RE: APPLICATION FOR VARIATION OF CONDITIONS UNDER SECTION 73 OF THE TOWN AND COUNTRY PLANNING ACT 1990

Planning Reference: 2023/62/92557/W

Site Address: Cellars Clough House, Marsden, Huddersfield, HD7 6LY

Drawing Scale 1:100 @ A1	Drawn By SDI	Approved By SDI
Drawing Status PLANNING		Date of Issue 25/01/2026
Drawing No GSL3324_GDR_DWG002		Revision A

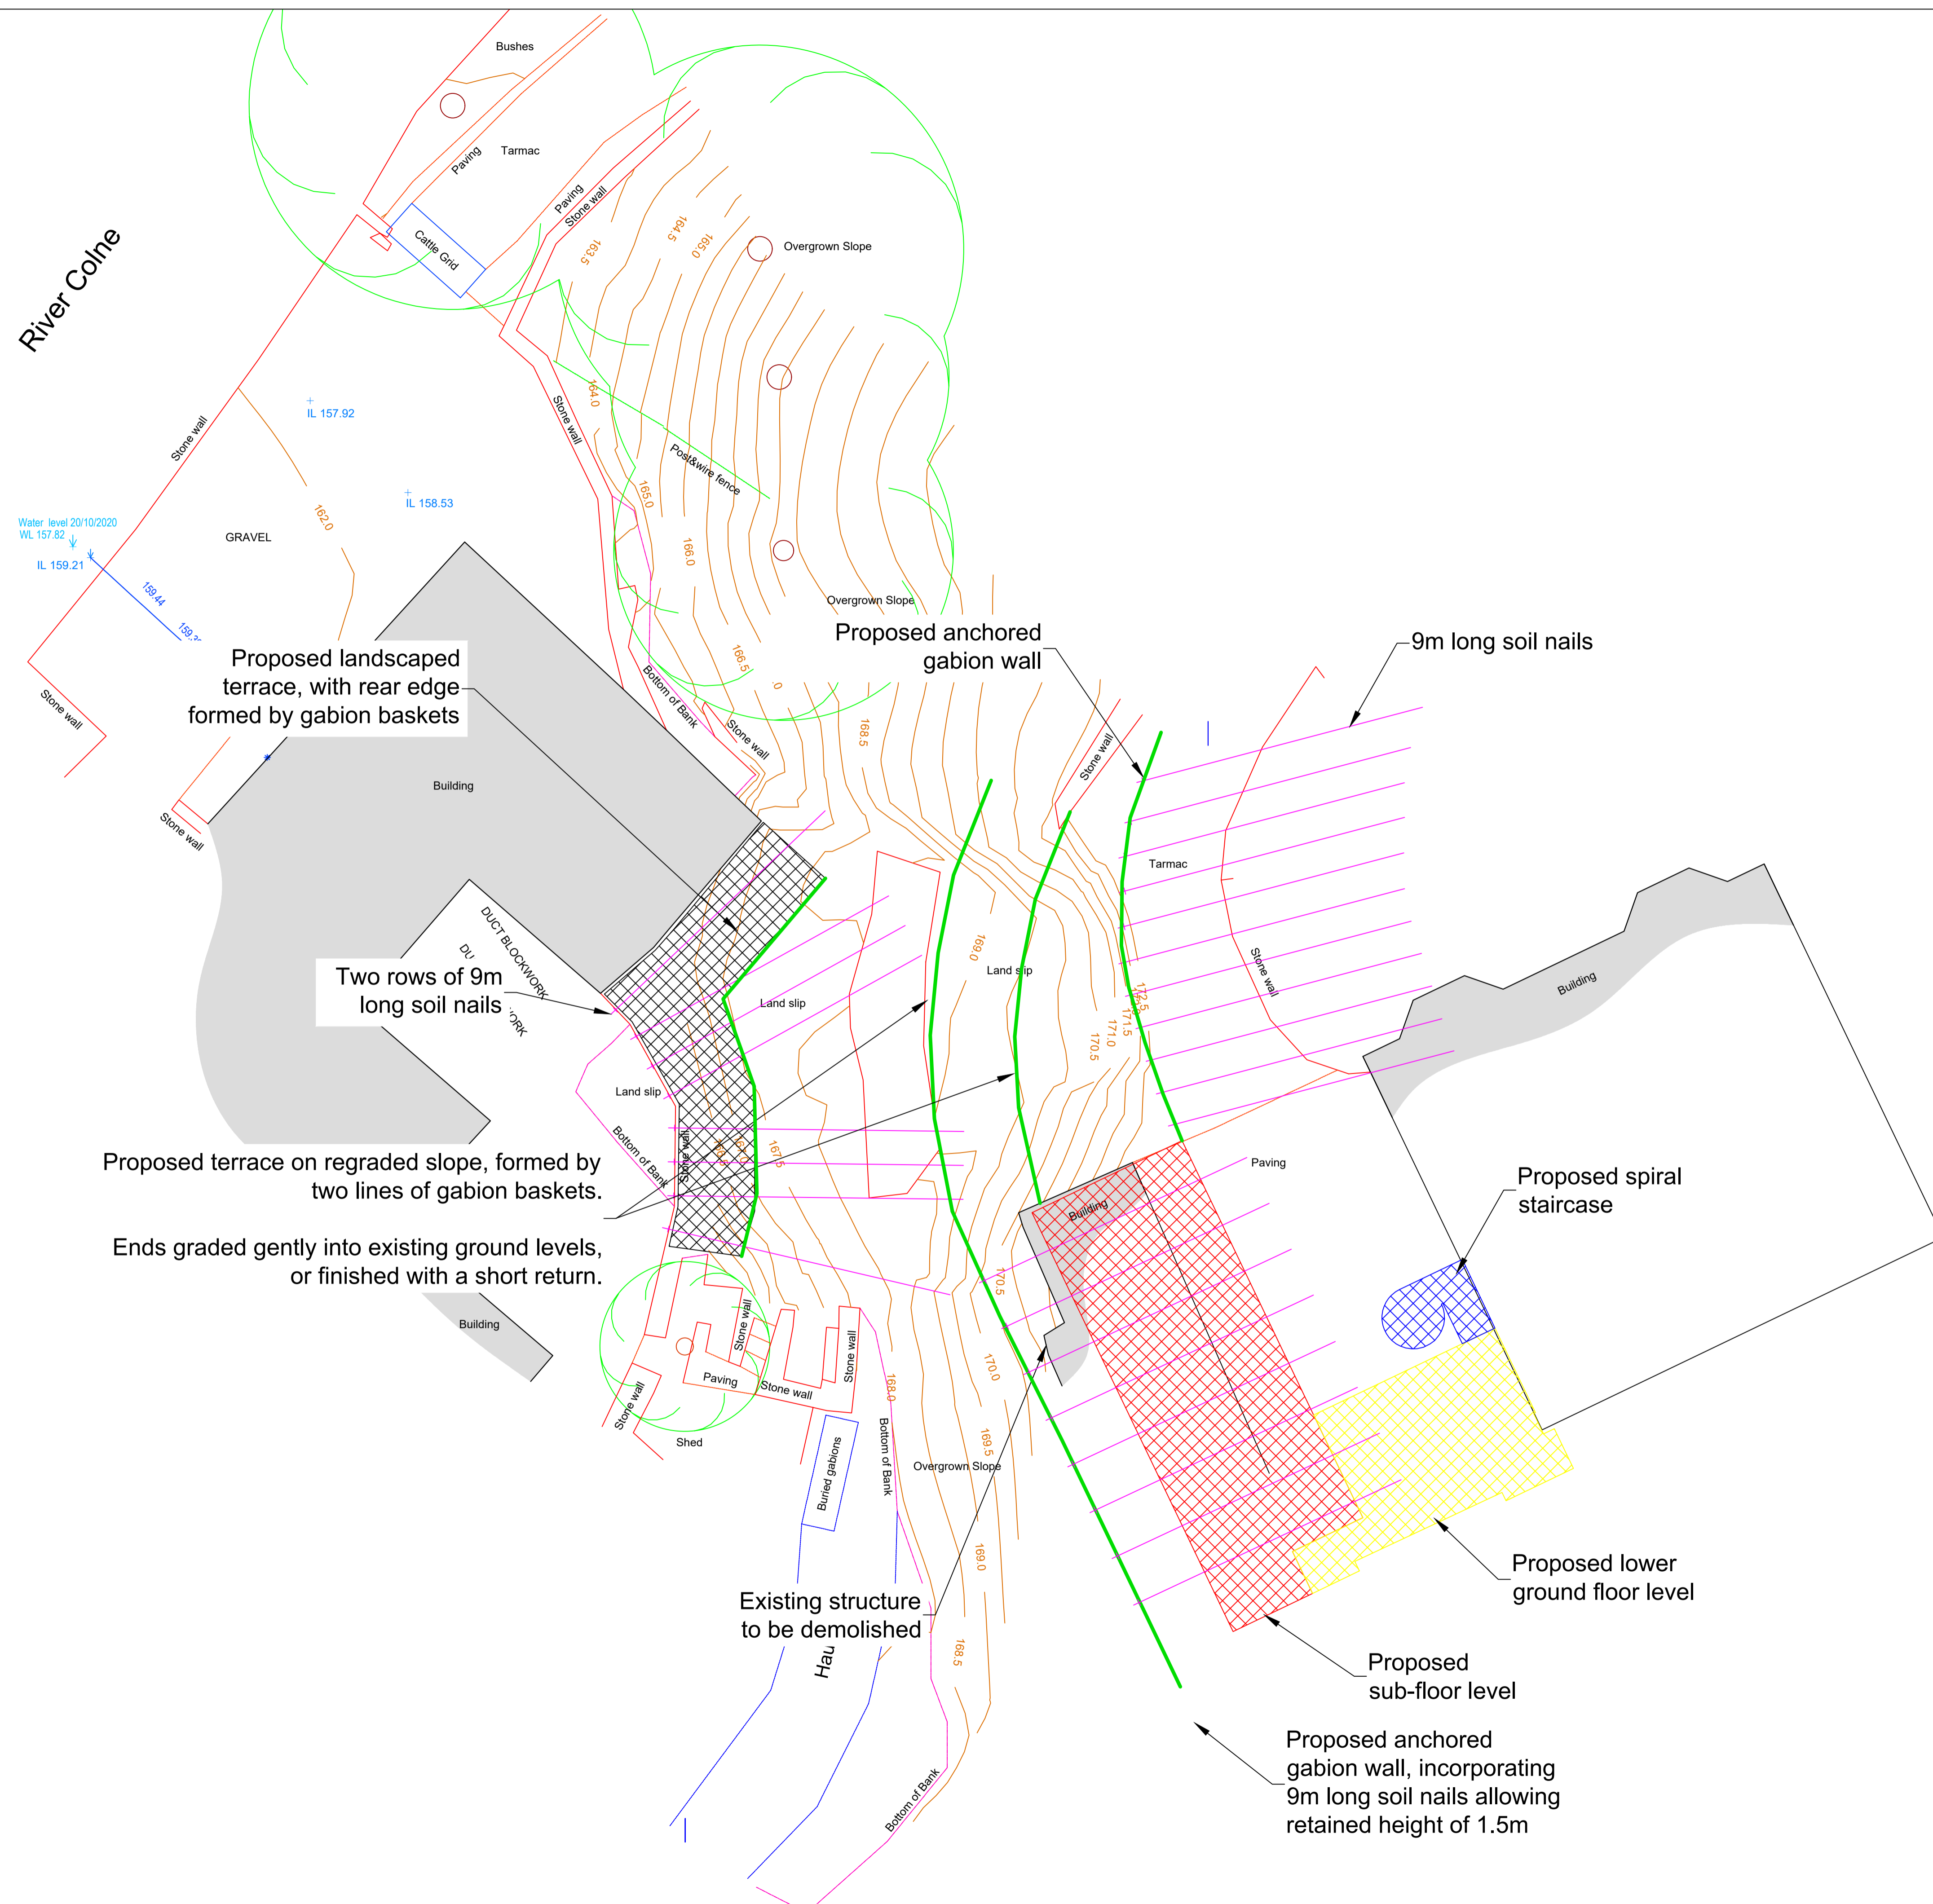
Condition 5 stipulates that all works relating to land stability should be in accordance with the details submitted. However, since the application was approved, a different geotechnical consultant was appointed to the project who has put forward an alternative proposal for the slope stabilisation than the one approved under the above application. We would therefore like to amend the drawing and document references named in the condition to refer to the new documents submitted by the Geotechnical Consultant, which reflect the new design.

Proposed Wording: *"All works hereby approved that relate to land stability shall be undertaken in accordance with the details as submitted in drawing numbers GSL3324_GDR_DWG001 and GSL3324_GDR_DWG002 and the details as contained within the Geotechnical Design Report (reference GSL_3324_GDR_001_Rev3) which shall be retained thereafter."*

The revised stabilisation method continues to address land-stability requirements and does not alter the building footprint or its relationship with the surrounding landform. The submitted layout that has been discussed and agreed with the neighbour at Coach House Healing & Wellbeing Centre. Drawings DWG001 and DWG002 are contained within the report.
